THE UNIVERSITY OF
SYDNEY

**University of Sydney – Centre for Obesity, Diabetes and Cardiovascular Disease –
Section 75W Application**

Section 75W application relating to the Part 3A approval for University of Sydney – Centre for Obesity, Diabetes and Cardiovascular Disease (CODCD) project has been submitted to the Department of Planning in January 2012.

SURVEY GROUND MODEL
FOR DESIGN AND FLOOD STUDY

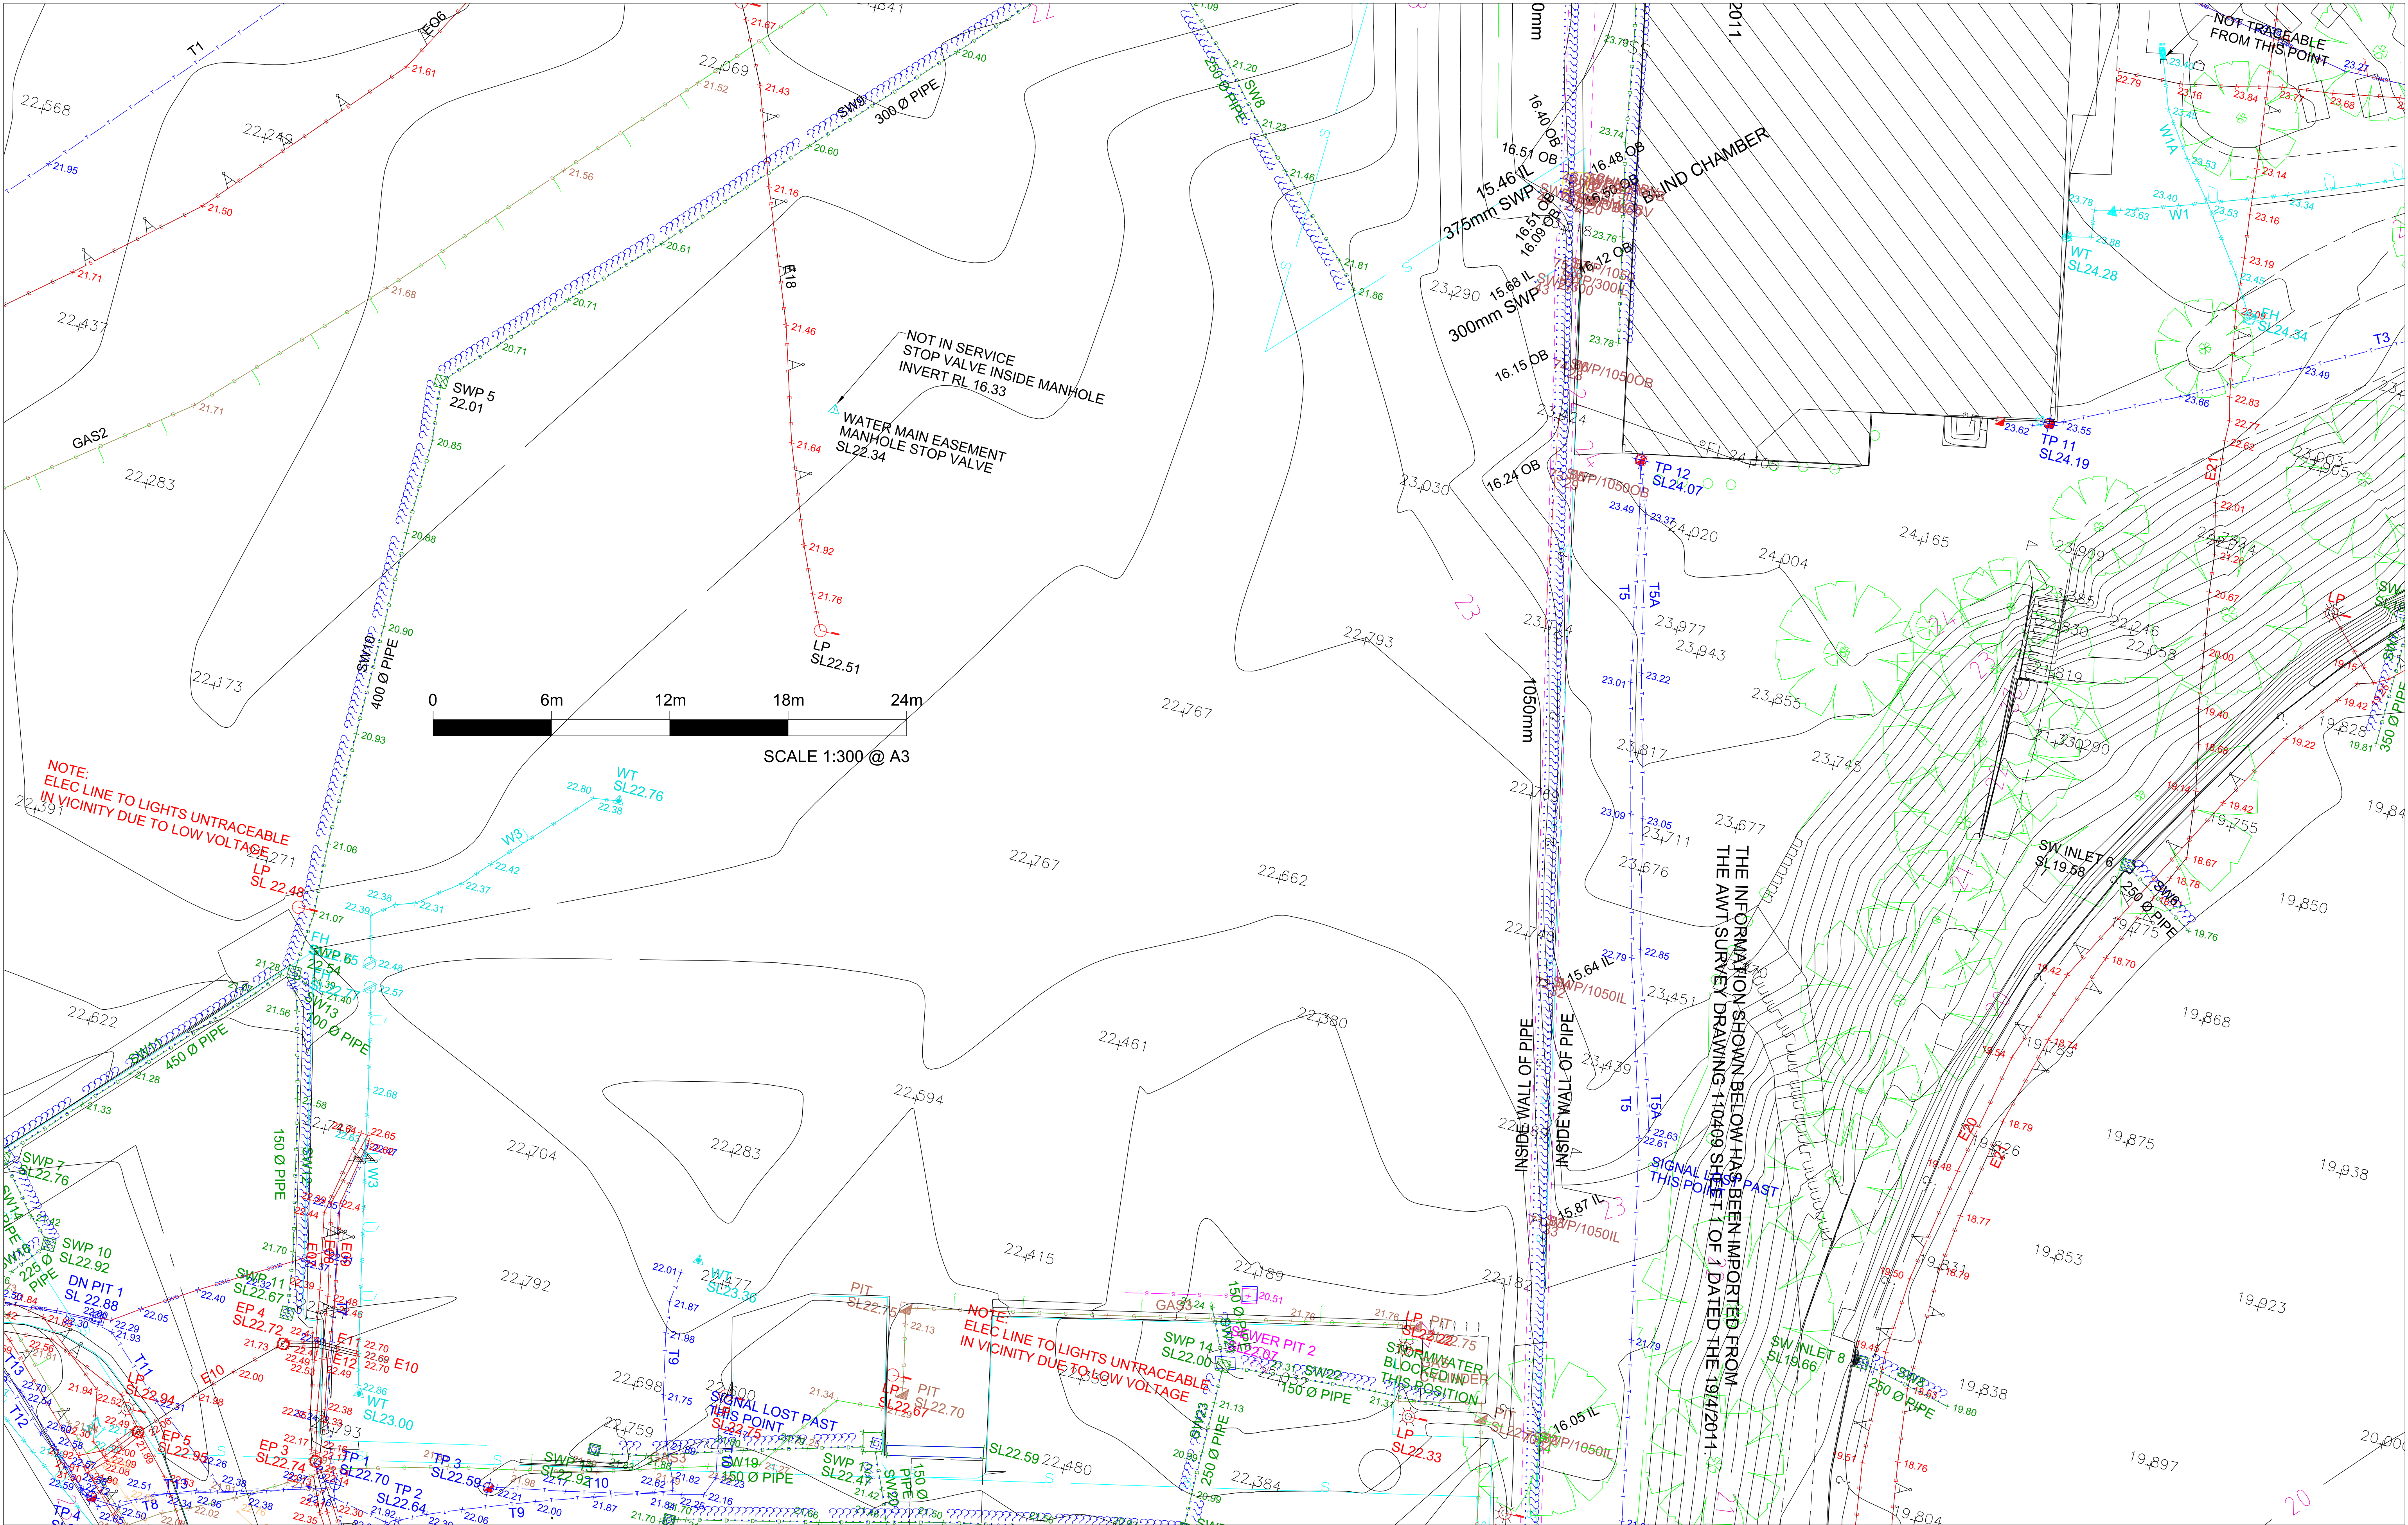
In response to the abovementioned application the City of Sydney submitted comments noting concern that the revised design indicates realignment of the originally proposed access road to the CODCD facility without documentation supporting or explaining the proposed change. Furthermore, it was noted that the proposed road has been constructed – The University of Sydney clarified that the constructed road is a temporary construction road.

The design drawings forming part of the Section 75W application have since been revised to indicate the road in the originally proposed location.

The University of Sydney hereby states that the CODCD project will be constructed in accordance with relevant development approvals and that any temporary construction structures will be removed upon the completion of the construction works.
